Re: **Framing Issue**
Location: Lot 27 Honeycutt Hills (457 Adams Pointe Ct. (Angier, NC))
JDS Project No.: RDU2411543
Date of Inspection: 11/20/24

A representative of JDS Consulting arrived on site to observe the issues reported to us by the client, which are presented, along with our recommendations, in this report.

Client: DRB GROUP-RALEIGH		ROOF	
Job: LOT 0.0027 HONEYCUTT HILL		Date: 05/09/24	
Plan Information: TOWNSEND-C		Job #: Sales Rep: KYLE GIBSON	
NOT TO SCALE		Phone: 24-4356-R01	
Drawn By: TAS

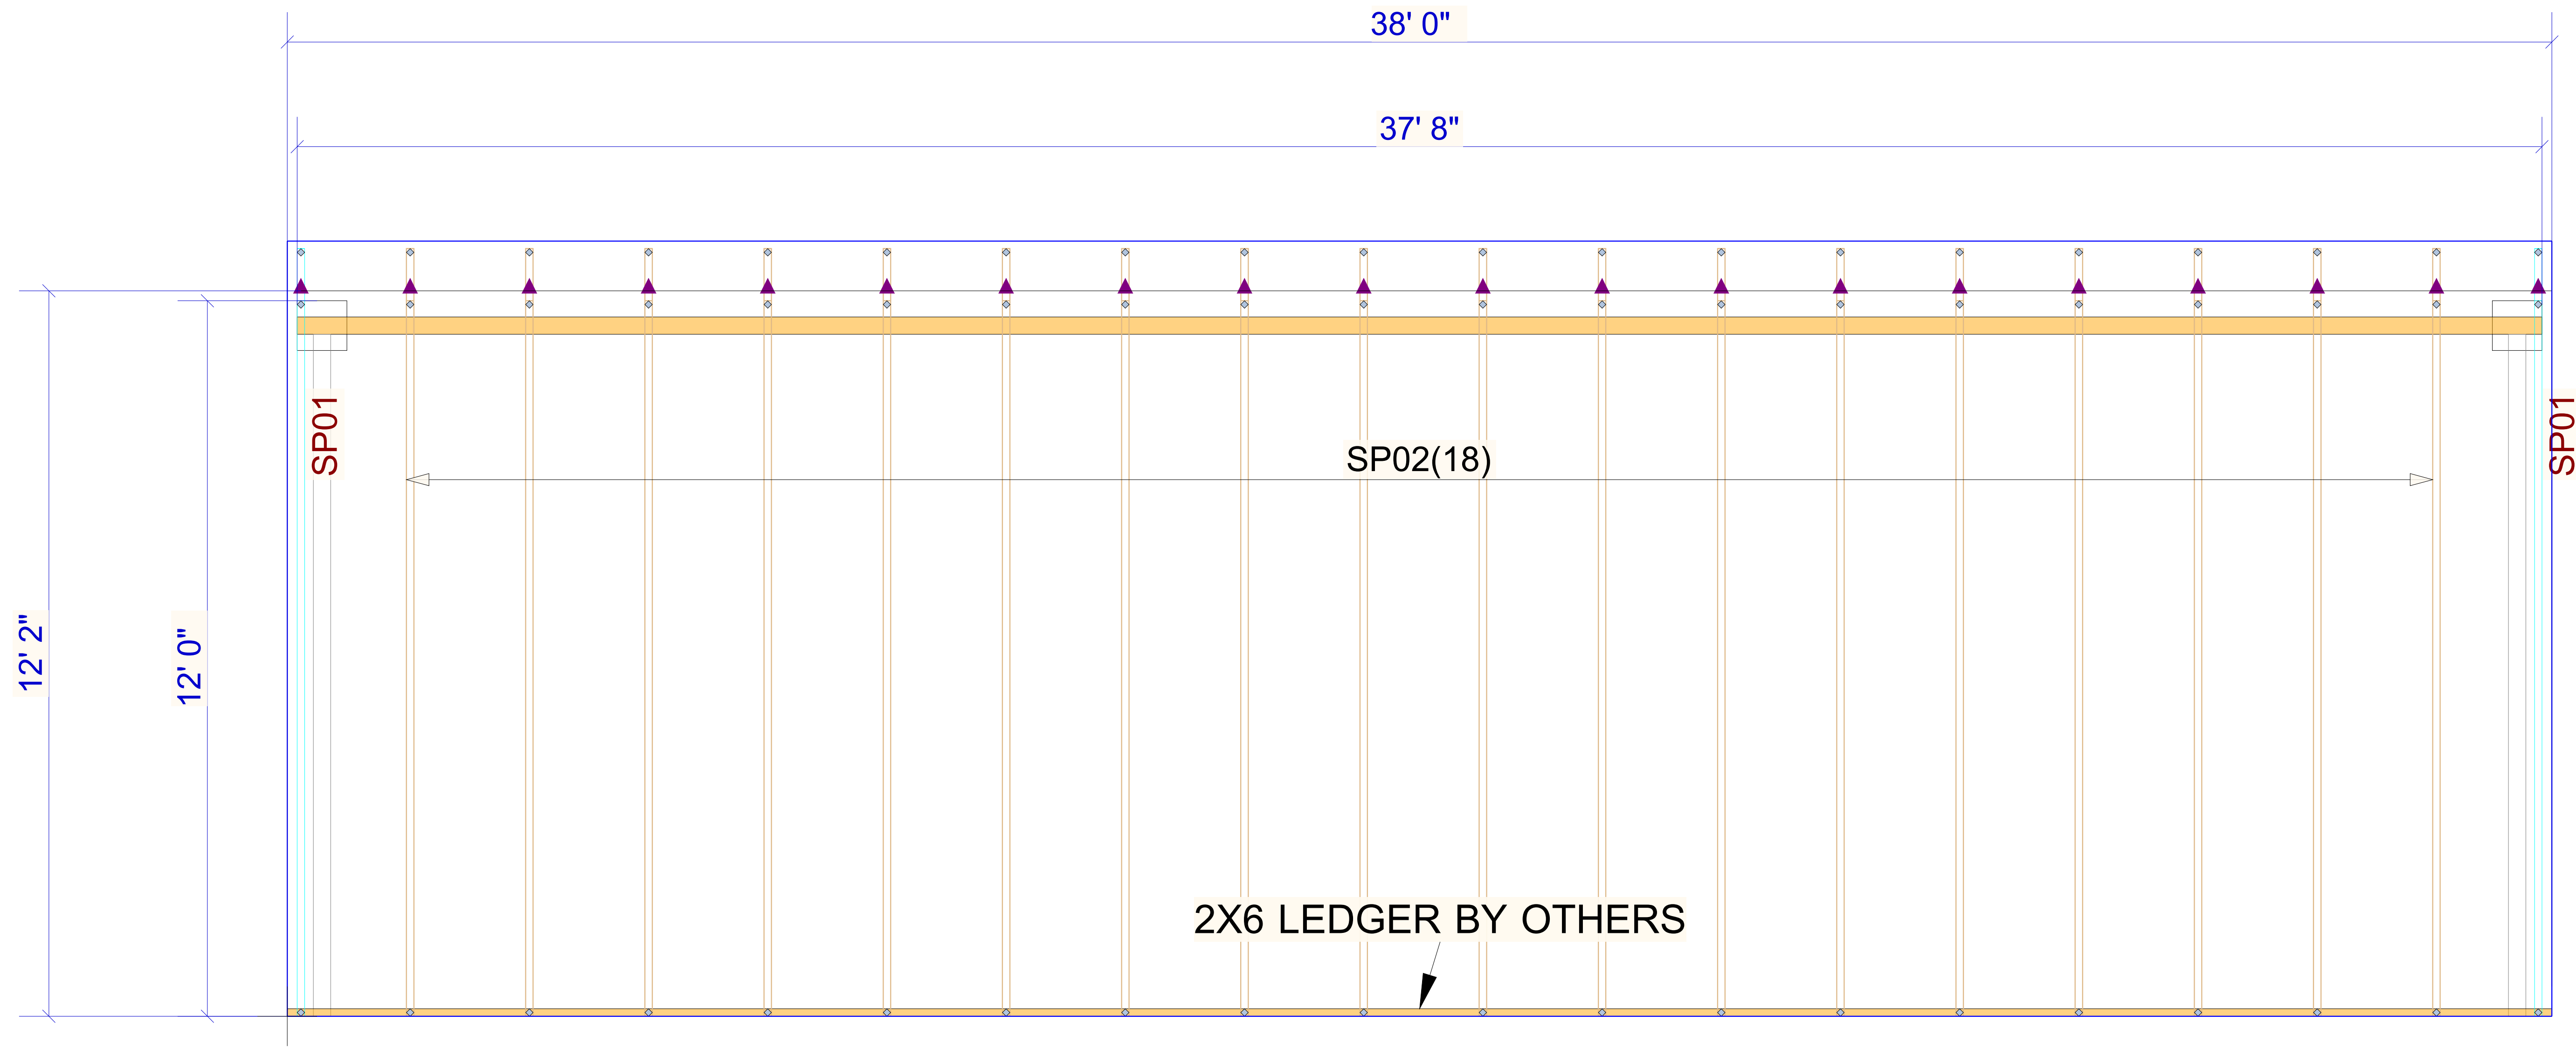
The client requests an evaluation of the missing J05 roof truss at the front right room of the 2nd floor. The R12 truss behind where the J05 is supposed to be hangers onto the J05 truss.

1. Install a 4' 2x8 header where the missing J08 roof truss should be.
2. Hanger the 2x8 header to the right-side roof truss with a LUS26 hanger. The left side of the header will bear on the left wall.
3. Hanger the R12 roof truss to the 2x8 header with a HTU26 hanger as per plan.
